Application no: 22/02847/DISC

Location: Heyford Park, Camp Road, Upper Heyford, OX25 5HD

Transport Development Control

TITLE: UPPER HEYFORD
PARCEL D2e (PHASE 5c)
DETAILS: PROPOSED ENGINEERING LAYOUT

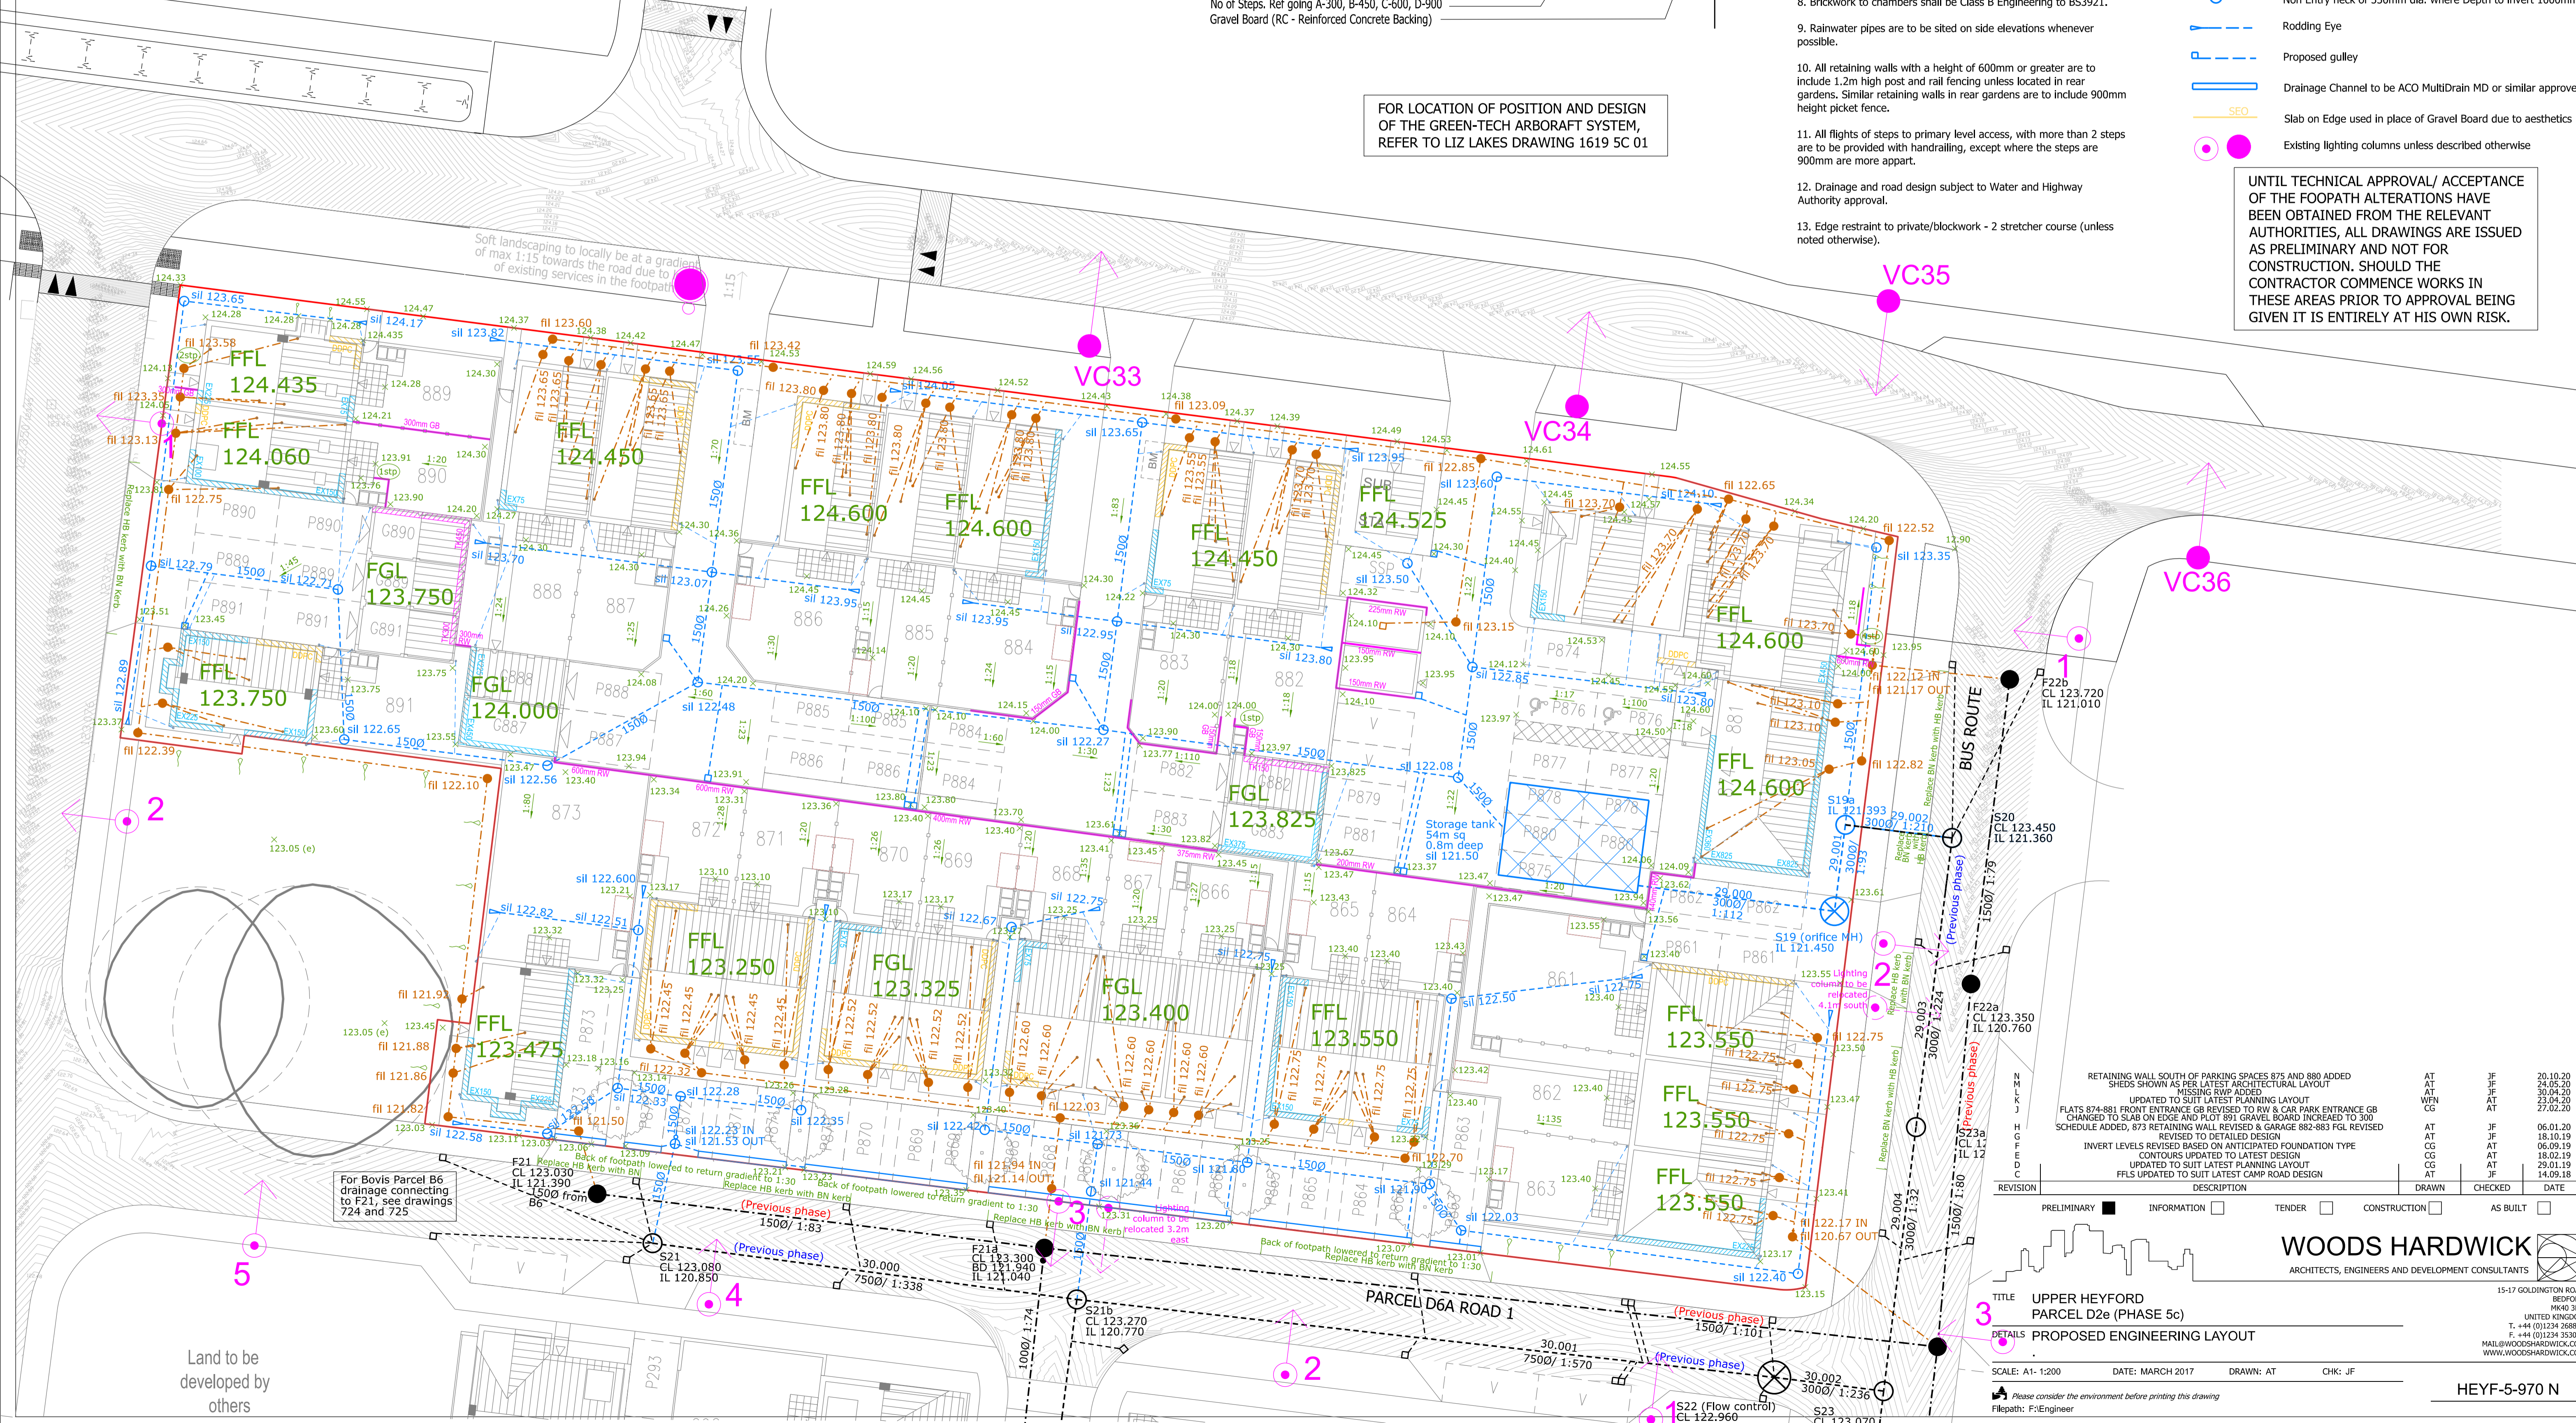
Properties 890, 878 and 880 have parking allocations that exceed the guidance within OCC's Maximum Parking Standards. Properties 878 and 890 are 1-bedroom dwellings with 2 allocated parking spaces, OCC's Parking Standards only permit 1 space per dwelling for 1 bed properties. Property 890 has an allocated 3 parking spaces, due to the inclusion of a garage, both the OCC Maximum Parking Standards and upcoming Vehicle and Cycle Parking Standards state that 3-bedroom dwellings should only have an allocated 2 vehicle parking spaces. As a result of this, the above properties will need to have their parking allocations amended, as providing too much parking has the potential to encourage a car dependent development and discourage the use of sustainable transport as per LTN 1/20.

In contrast, properties 874 and 879 have parking allocations that are below the minimum number of spaces set out within OCC's Maximum Parking Standards, which in itself has its own potential issues. Properties 874 and 879 are 2-bedroom properties, however they only have 1 allocated parking space, below the 2 recommended within the OCC Maximum Parking Standards and the guidance within the 2022 Vehicle and Cycle Parking Standards for rural developments. The allocation for these properties must be amended, as an inadequate parking provision can lead to overspill onto the adjacent highway network which in turn can present several issues in relation to safety and convenience.

Within this development 4 of the 4-bedroom properties (882, 883, 887, 888) have 1 vehicle space and 1 garage space. I raise concern here as I note no condition prohibiting the conversion of garages into inhabitable spaces. If this was to occur, it would leave the largest properties within this development with 1 vehicle space and is likely to lead to overspill parking throughout the development.

This phase outlines plans for houses ranging from 861 to 891 which is a proposal of 31 houses, OCC policy for visitor spaces is approximately 1 space for every 5 properties, meaning this development would require 6 spaces.

Property 876 has two disabled spaces do not conform to guidance in relation to space length, all disabled bays must measure a minimum of 5.5m in length, in order to provide the required accessibility for users.
